PROJECT TITLE Candelaria Apartments TYPE OF SUBMITTAL Drainage Plan Approval
 ZONE ATLAS PAGE NO. H22/D4 CITY ADDRESS Approximately 12,000 Candelaria Rd., NE
 LEGAL DESCRIPTION Lot B of the Summary Plat of Division of Block 31B of Brentwood Hills Subdivision
 ENGINEERING FIRM Greiner Engineering CONTACT Lowell Lester
 ADDRESS 2601 Wyoming Blvd., NE PHONE 505-292-1936
 OWNER John N. Freeman CONTACT Greg Fumbaugh
 ADDRESS 72617 Tramway Vista, NE PHONE 505-292-3942
 ARCHITECT Design Collaborative SW CONTACT Nelson Hodges
 ADDRESS San Felipe, NW #6 PHONE 843-9639
 SURVEYOR Greiner Engineering CONTACT George Mundell
 ADDRESS 2601 Wyoming Blvd., NE PHONE 505-292-1936
 CONTRACTOR NA CONTACT _____
 ADDRESS _____ PHONE _____

REF: GRADING AND DRAINAGE PLAN FOR CANDELARIA APARTMENTS (H22-D44) RECEIVED
DECEMBER 20, 1984

REF: DRAINAGE PLAN FOR CANDELARIA APARTMENTS (H22-D44) DATED 5/10/85

REF: REVISED PHASING PLAN FOR CANDELARIA APARTMENTS (H22-D44) REVISION
DATED 9/8/85

CANDELARIA APTS.  
DRAINAGE & GRADING PLAN

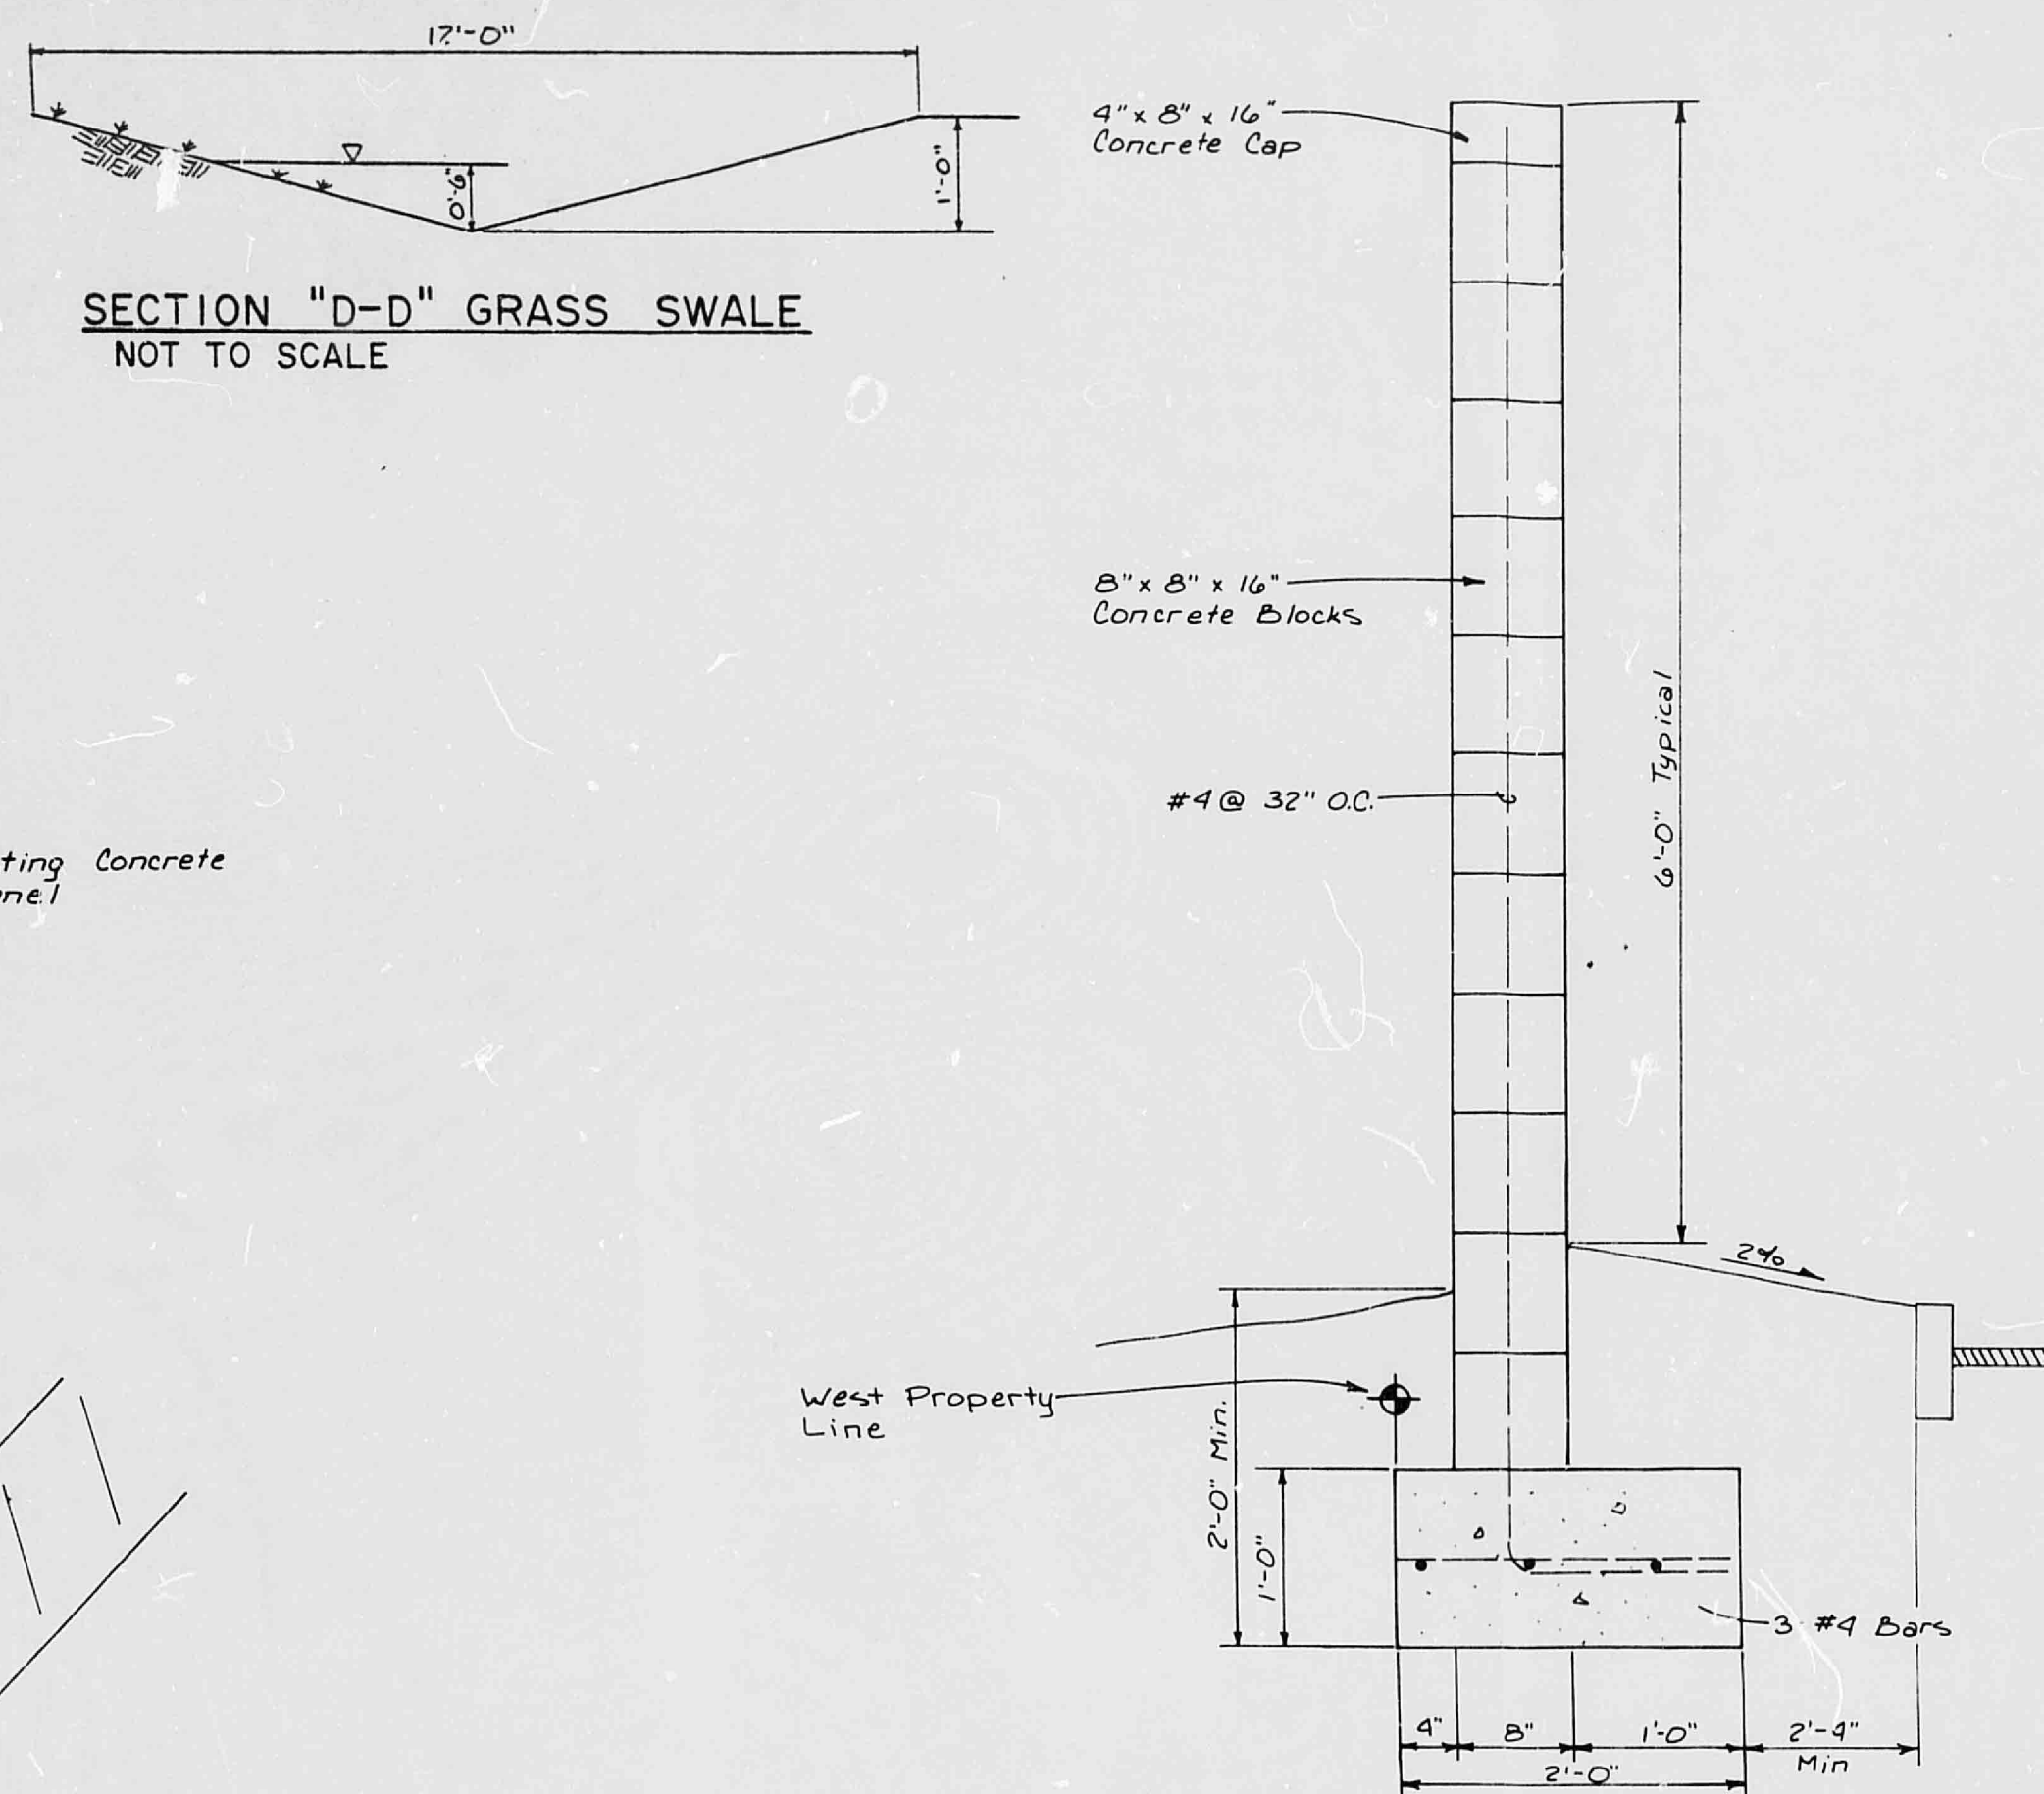
The above referenced submittal is acceptable as far as it is; however, prior to final approval, please provide a revised plan with additional detail or spot elevations to clearly show the interfacing with the property to the west. Also, please provide the finished floor elevation of the structure off-site and the hydraulics associated with the rundown.

TEMPORARY EROSION CONTROL OUTLET  
TO BE INSTALLED FOR PHASES 1-3  
NOT TO SCALE

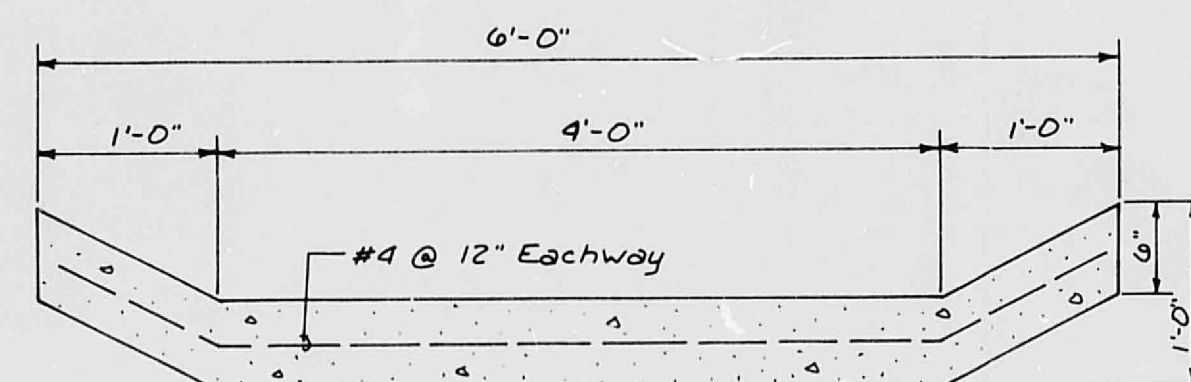
Based on the information provided on your October 9, 1985 resubmittal, revisions as indicated are acceptable. The temporary Erosion Control outlet must be coordinated with the City Design Section for the temporary measures. The proposed run-down must also be in place before the temporary outlet is allowed to release into the channel. Please advise your client that only temporary CO's can be issued until phase IV and phase V are completed and inspected.
